Planning Report

Application Number: 22/00097/FLH

Application Location: 83 Ebbisham Road, Epsom, Surrey, KT18 7NS

Proposal: Erection of single storey rear extension

Drawing Title
 Proposed Ground Floor Plan

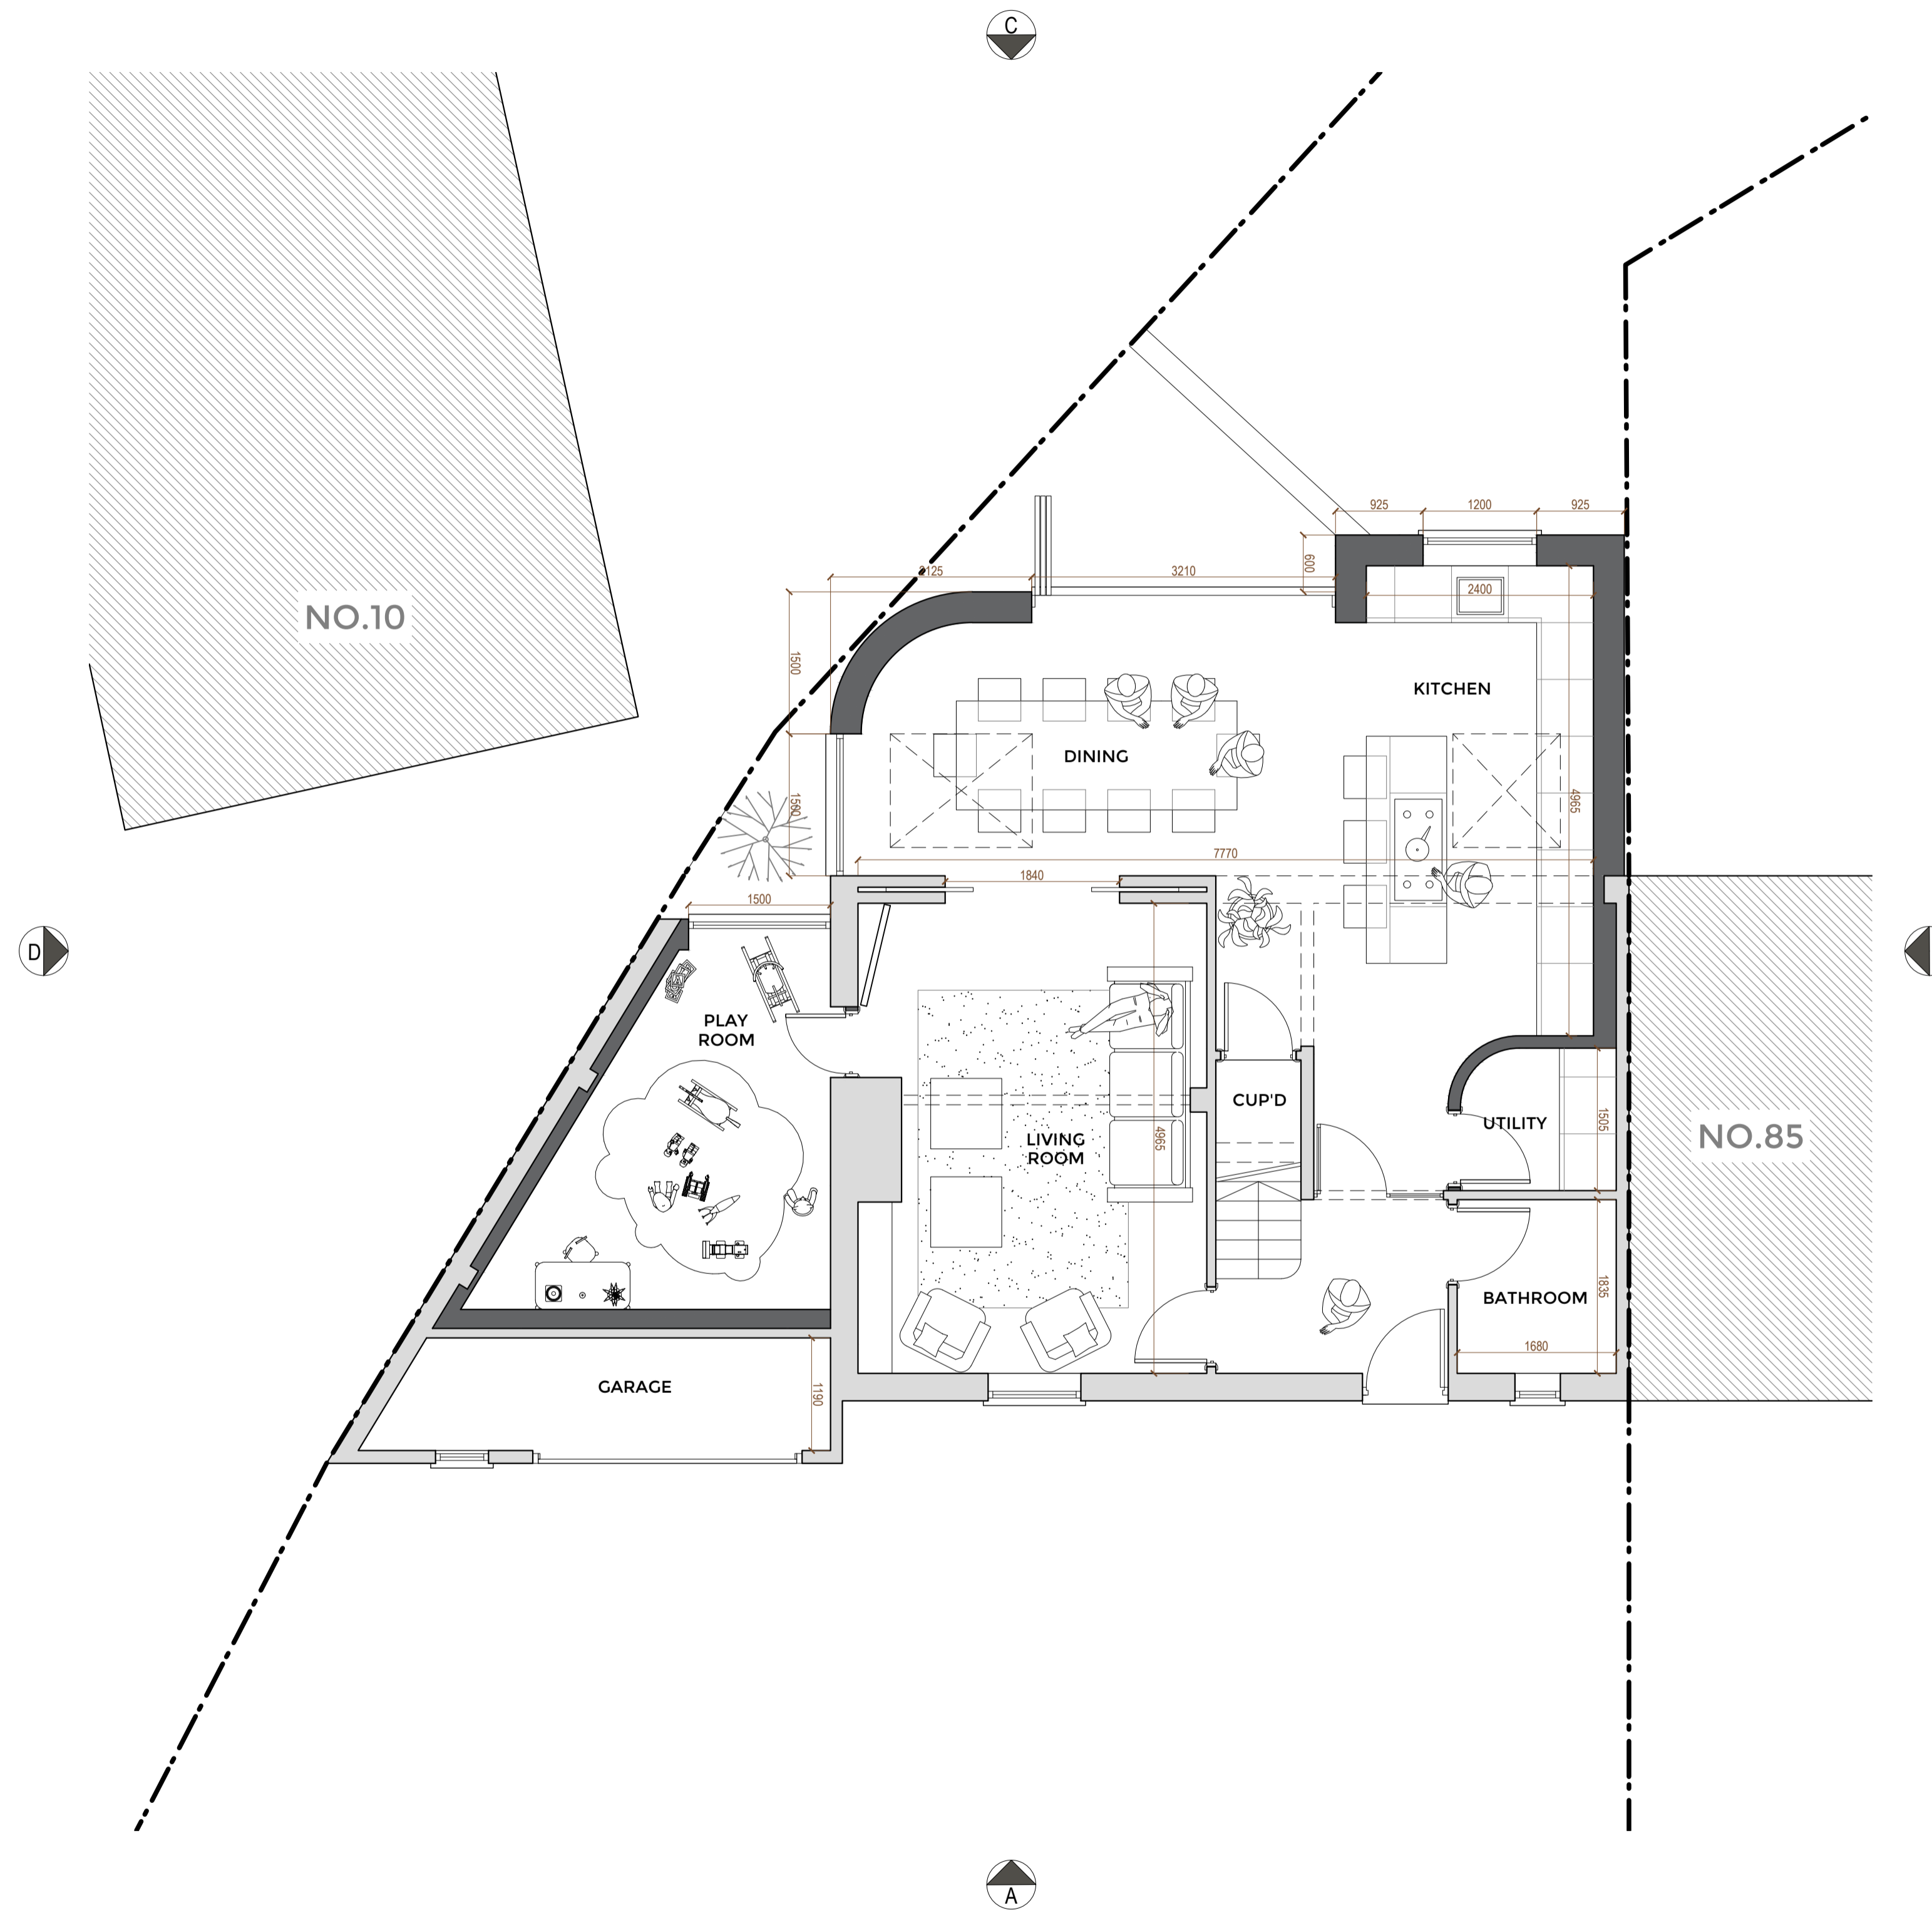
The proposal seeks to erect a single storey rear extension, approx. 4.9m at the deepest point and the conversion of a storage room to the rear of the garage into a habitable room.

The proposed single storey rear extension is considered to be acceptable in scale, form and design, appearing as a subservient addition that would neither dominate nor compete with the existing form of the host dwelling, that due to its shape and the curved wall, respects the shape of the plot.

Drawing Title
Proposed West Elevation

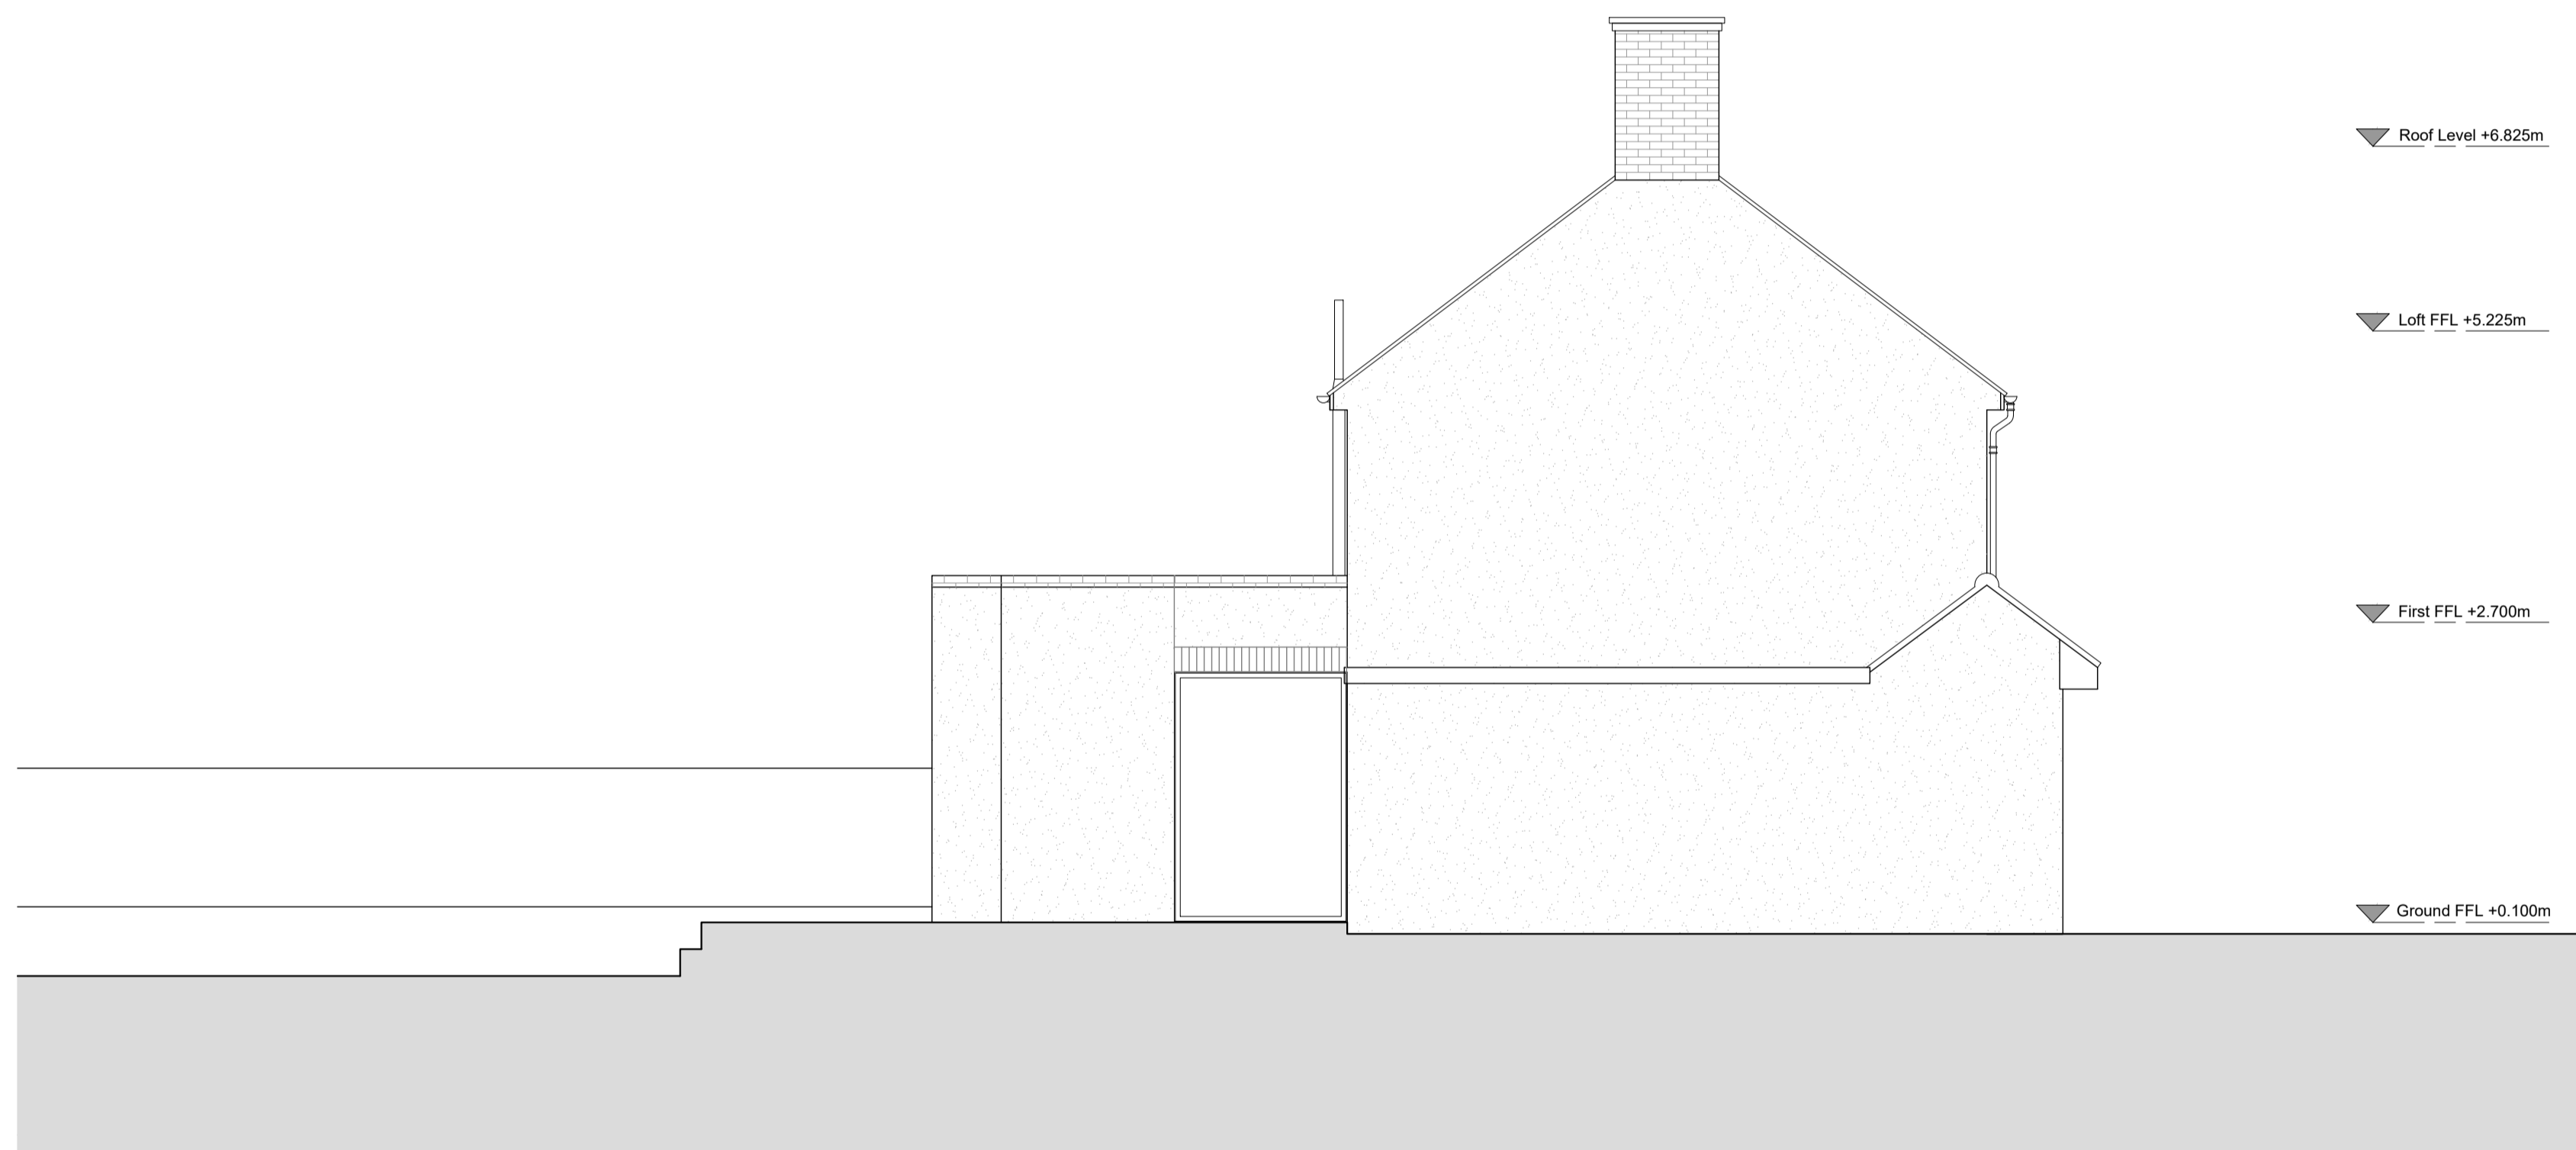
As a result of its orientation to the rear of the host dwelling, the proposed single storey extension would not be visible from the public realm and would therefore have no visual impact upon the character and appearance of the existing street scene.
